Chatswood Chase Shopping Centre Table of Response to Submissions

The table below summarises the responds to issues raised as part of the exhibition of the EAR. The table should be read in conjunction with correspondence from WCC dated 8 August 2007 provided in Appendix A.

01 SECTION - NEW RETAIL TENANCY
--- SCALE 1:100 VICTORIA AVE

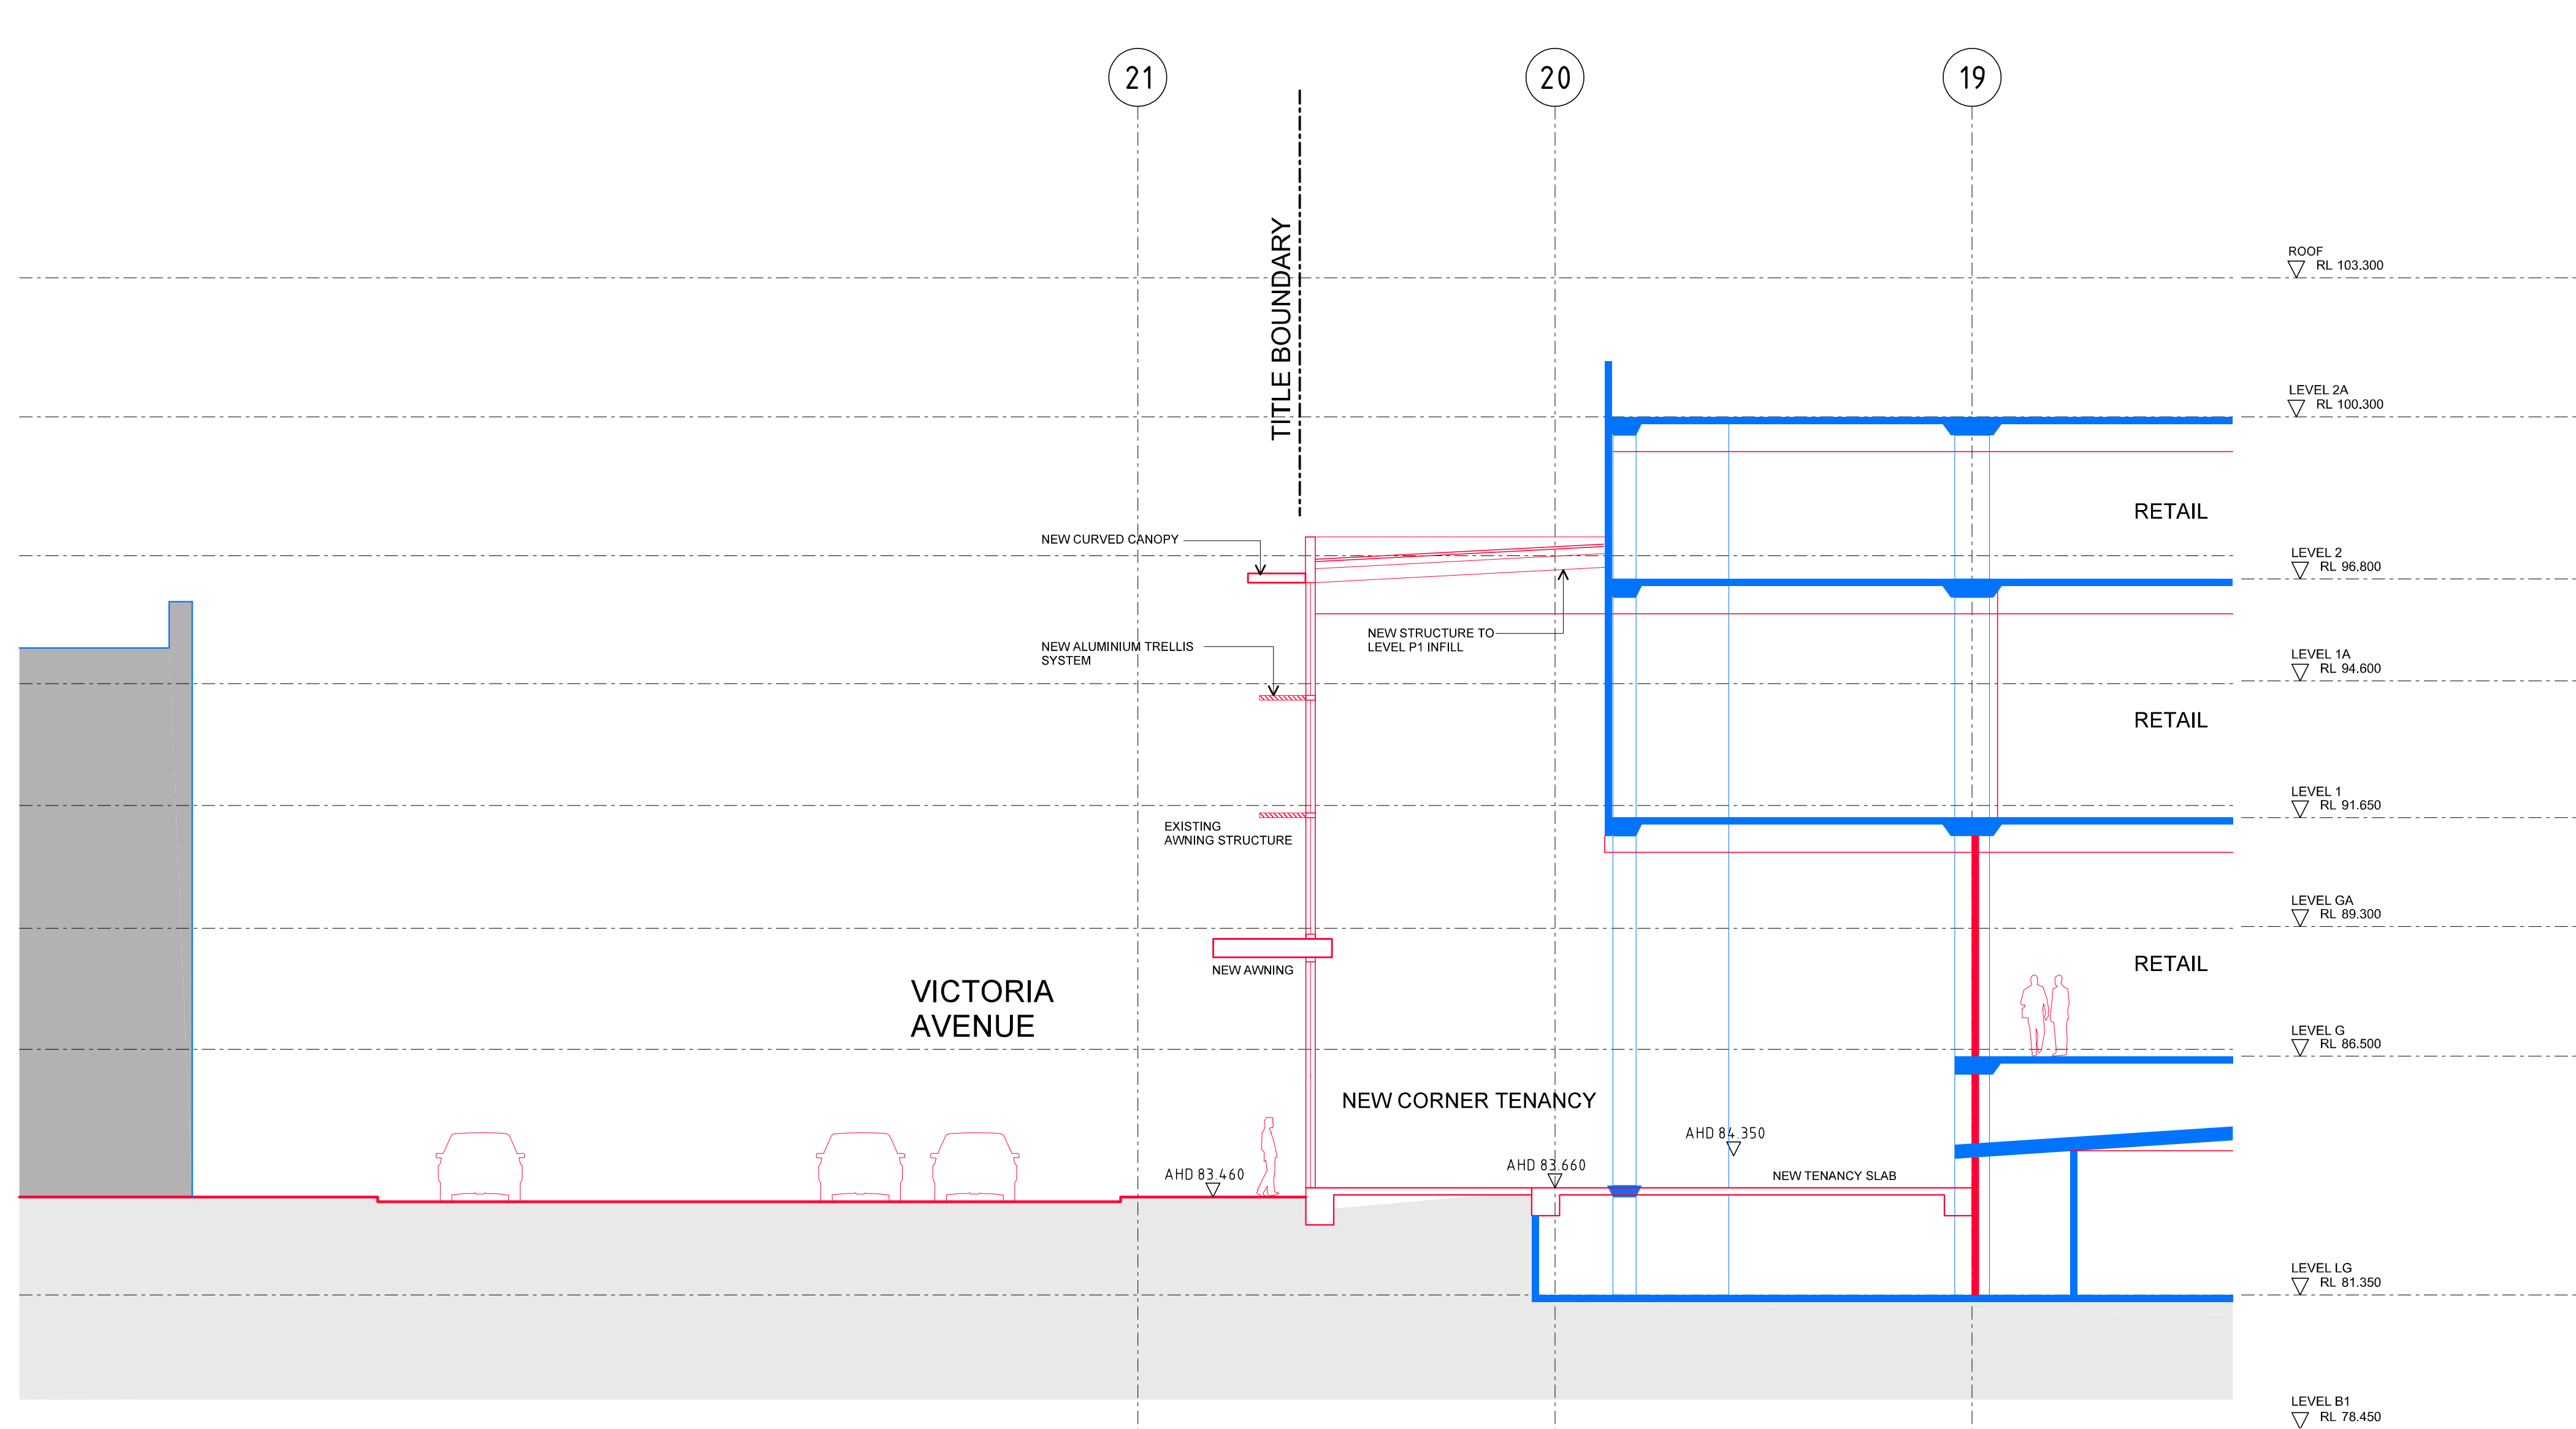
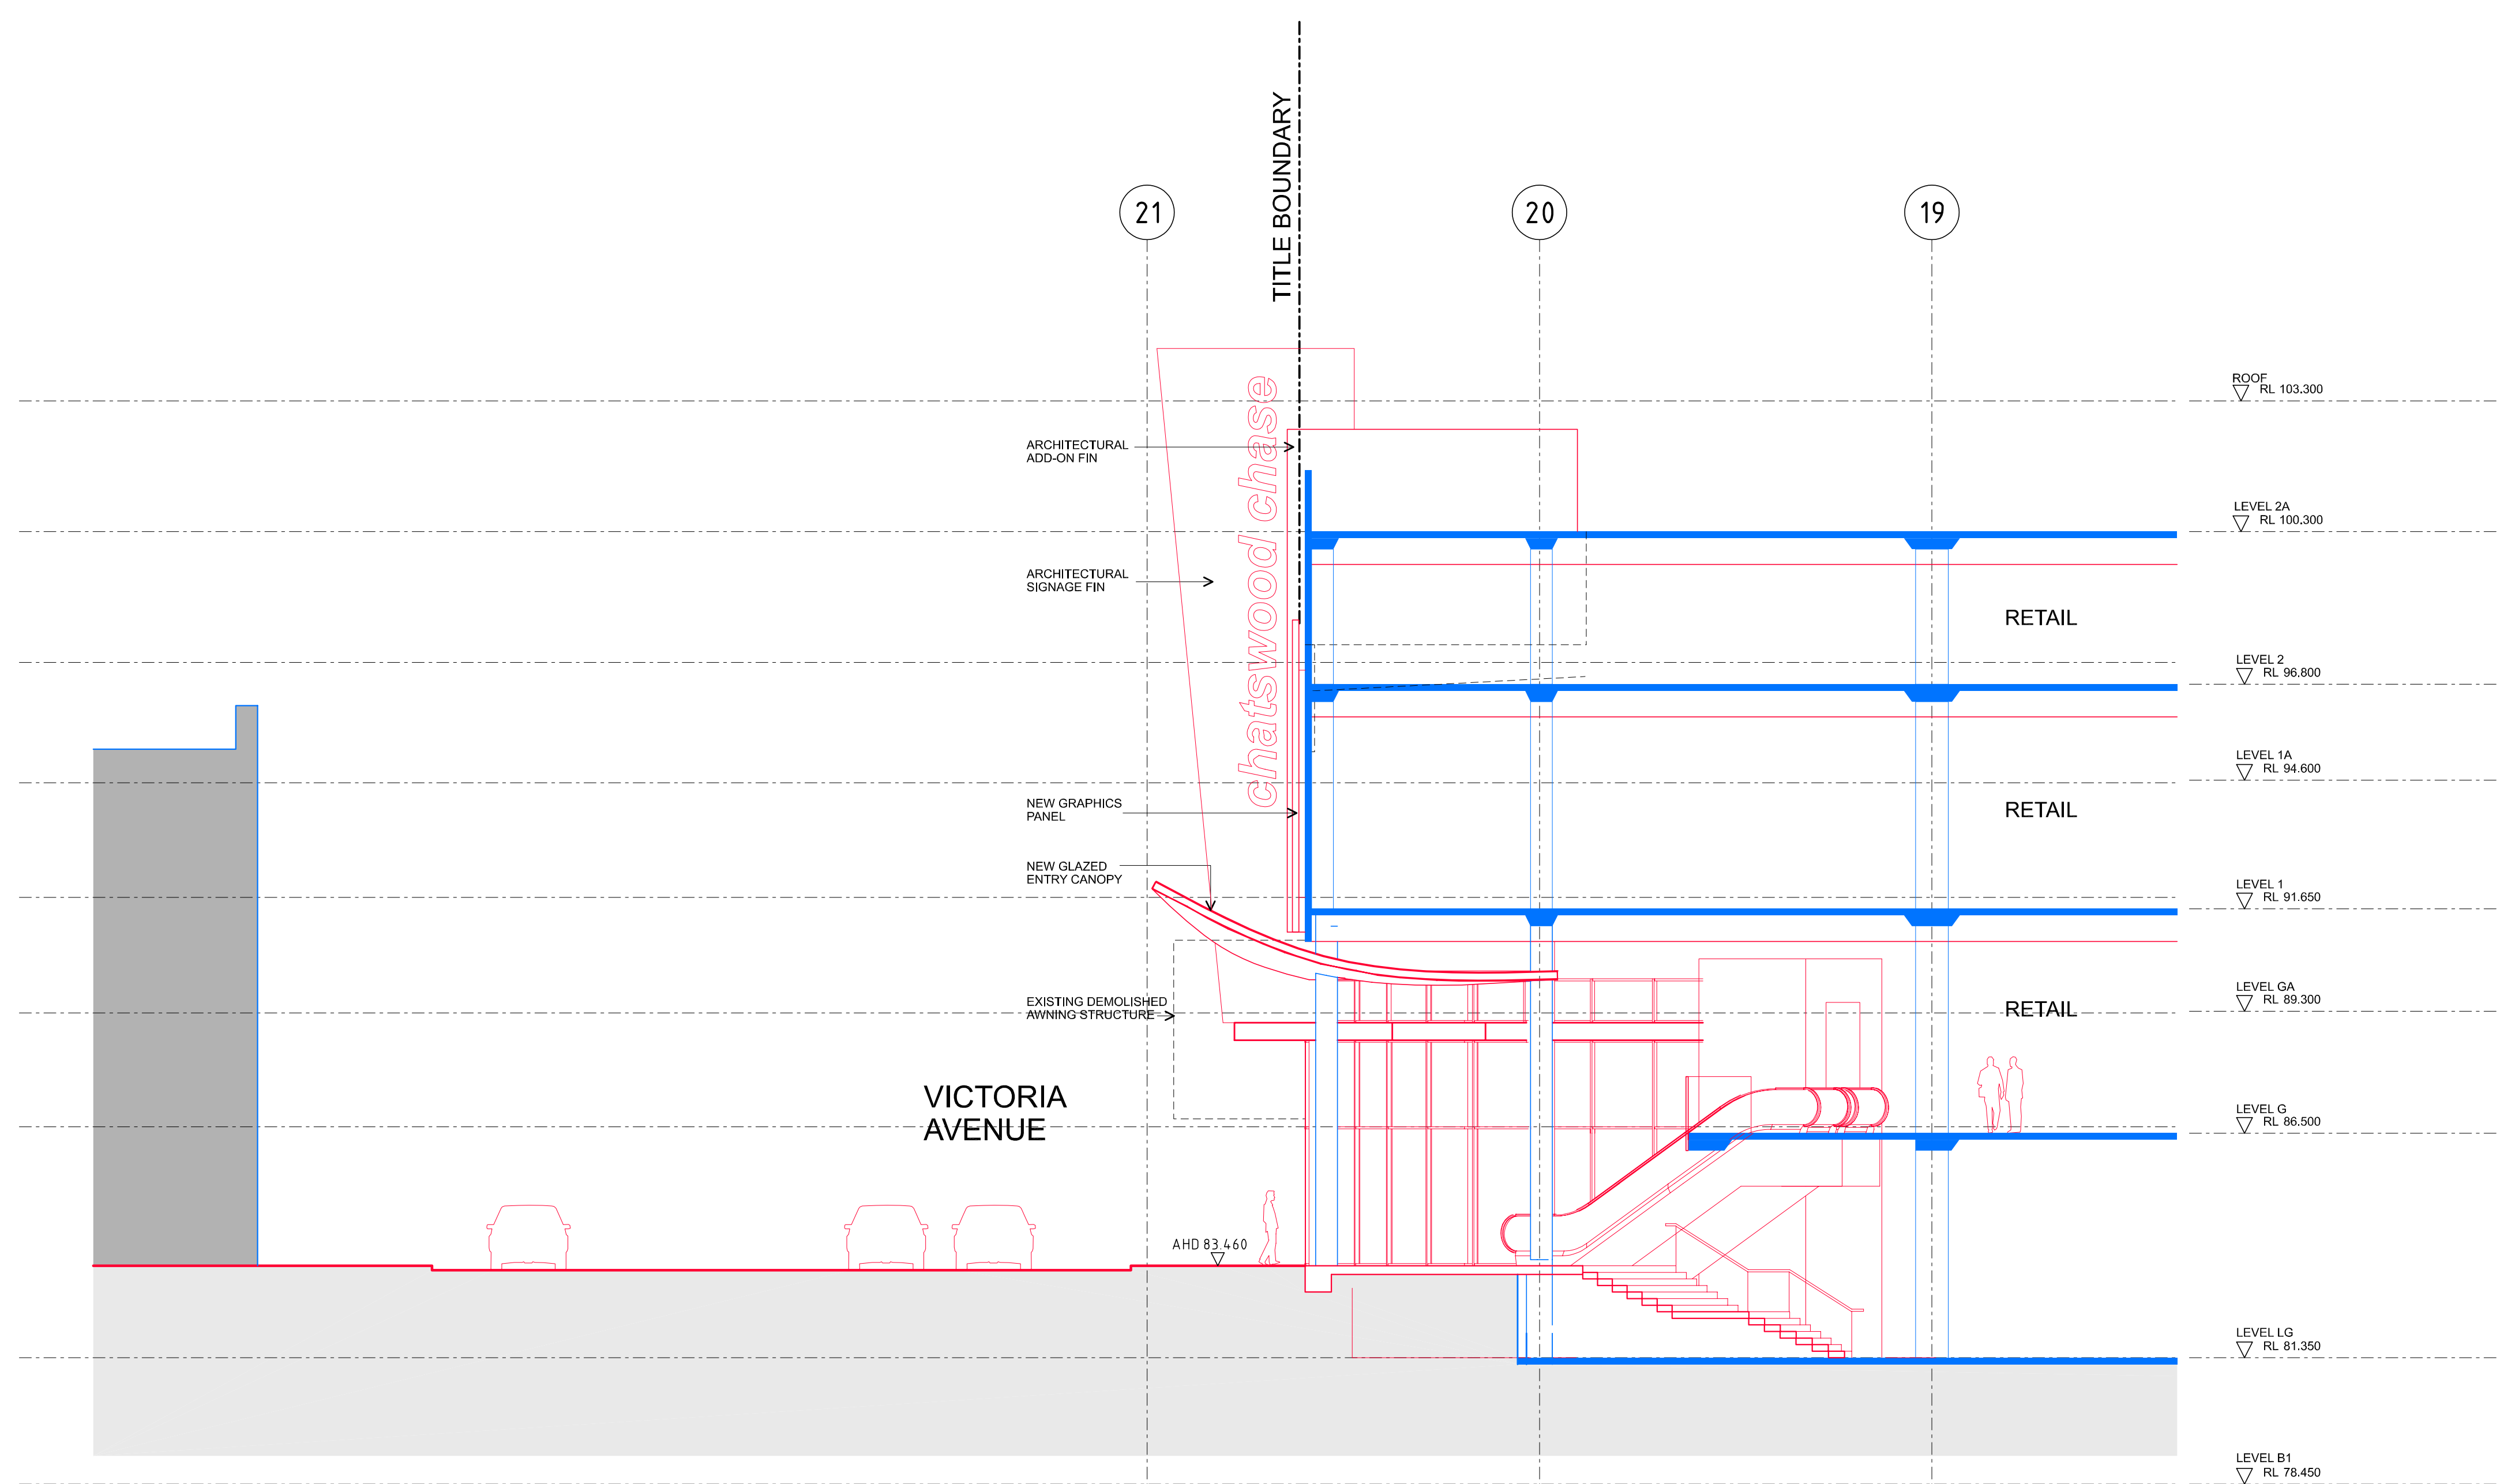
No.	Comment	Response
3	<p>Glazed Element- Victoria Avenue</p> <p>The glazed/transparent element adjacent to the east of the entry has changed in its form from the April 2006 design where it increased in horizontal width as it increased in height to a form that now is proposed to increase not only in width but also depth as it increases in height. The extent of encroachment into the road reserve increases to 1 to 2 metres and includes areas of leasable floor area on Levels 1 and 2. It also forces the Chatswood Chase signage blade to increase in depth to be readable from afar such that it appears to extend to the line of the kerb or more.</p>	<ul style="list-style-type: none"> - The Chatswood Chase signage blade will project no closer to the kerb than 600mm. - The glazed element adjacent to the east of the Victoria Avenue entry is fixed over the existing façade. There are therefore no areas of leaseable floor area outside the site boundary. - The glass is colour-backed not transparent. - The glazed element splay out to maximize articulation.

3b	<p>On the basis of the above:</p> <ul style="list-style-type: none"> - The depth of the blade is considered excessive. It is considered that the design of both elements should be reviewed to maintain a constant depth over the height of both elements. - It is considered that the blade encroachment should be less than 3 metres and other encroaching elements should be adjusted such that the "Chatswood Chase" signage can be read from afar. 	<p>Council has previously encouraged increasing the depth of these elements. Maintaining a constant depth will diminish the dynamic quality of these elements and the level of articulation. We would prefer to retain current principles. We believe the sign should be readable from a distance; most viewing will be carried out from moving vehicles.</p>
4	<p>Signage Frame - Victoria Avenue</p> <p>It is considered that the building in the location needs to be redesigned to introduce some light and appearance of transparency in the location that addresses both the south and east views to the site and that the major tenant signage location and design be reconsidered as part of that process.</p>	<ul style="list-style-type: none"> - The sign now returns onto the splayed wall. - The panels will not be transparent, however, framing of the signage frame will give depth to the signage and integrate it with the façade treatment of the centre along Victoria Avenue. - Major tenants signage or logo will be displayed on each face of the sign, being visible from the south, along Neridah Street and east along Victoria Avenue.
